From: Dourte, Richard H.
Sent: Monday, April 25, 2011 4:39 PM
To: 'Dan Wilson'
Cc: 'Victor Chavez'; Cherne, Curtis
Subject: RE: 7020 Prospect Place NE, drainage problem.

Re: Peltier, Gustafson & Miller Bldg Drainage Improvements Grading and Drainage Plan

Engineer's Stamp dated 9-27-06 (H19/D61)

Based upon the information provided in your submittal dated 9-27-06, the above referenced plan cannot be approved for Grading and Paving Permit until the following comments are addressed:

### GRADING PLAN

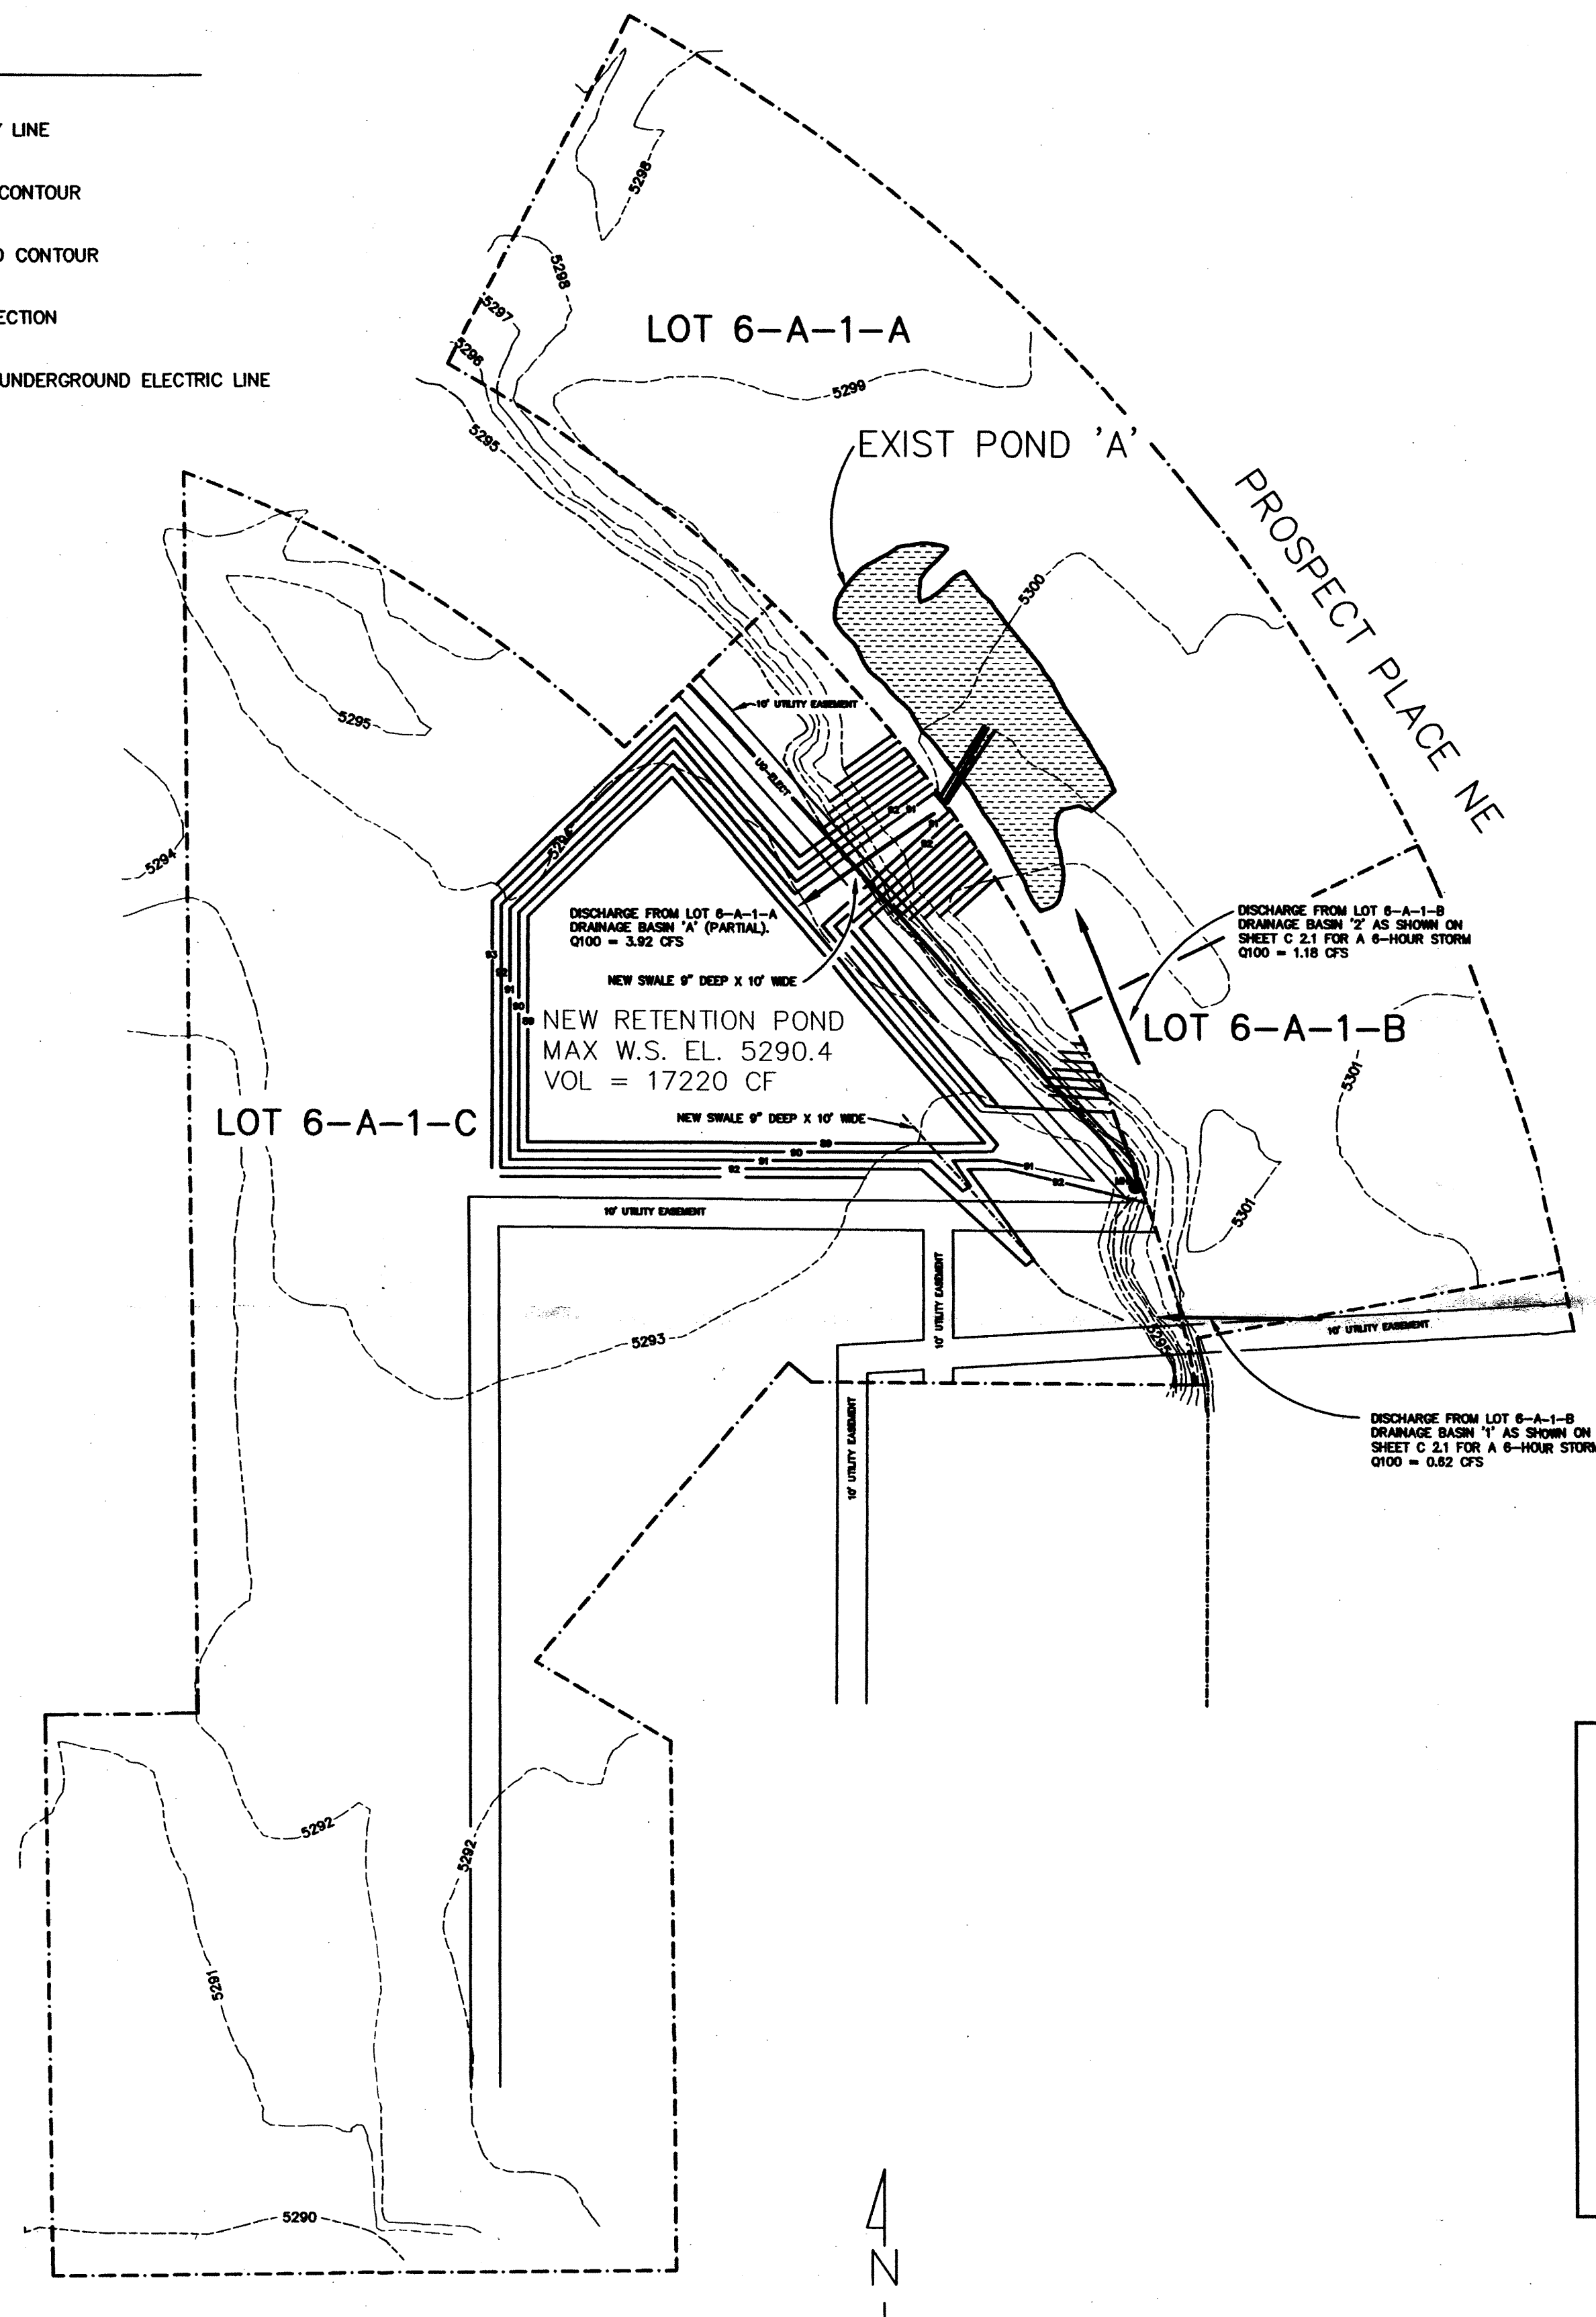
- Provide an inlet or grate on the new 6" pipe to prevent large debris from entering the storm drain.

- Will some type of screen or filter be required around the clogged inlet in the parking lot to prevent future clogging?

The proposed grinder pump with the outlet discharging these minor flows onto the parking lot just north of this building should correct the concern regarding the ponding of water on the west side of the building located at 7020 Prospect NE.

The engineer, Mr. Chavez has indicated to me that the 3 inch pipe from the storm drain inlet that connects into the 6 inch pipe will suffice. Previous drainage problems due to this inlet were created by the inlet grate being clogged not by pipe size. I have been told that the owner has been notified and plans to maintain this inlet grate.
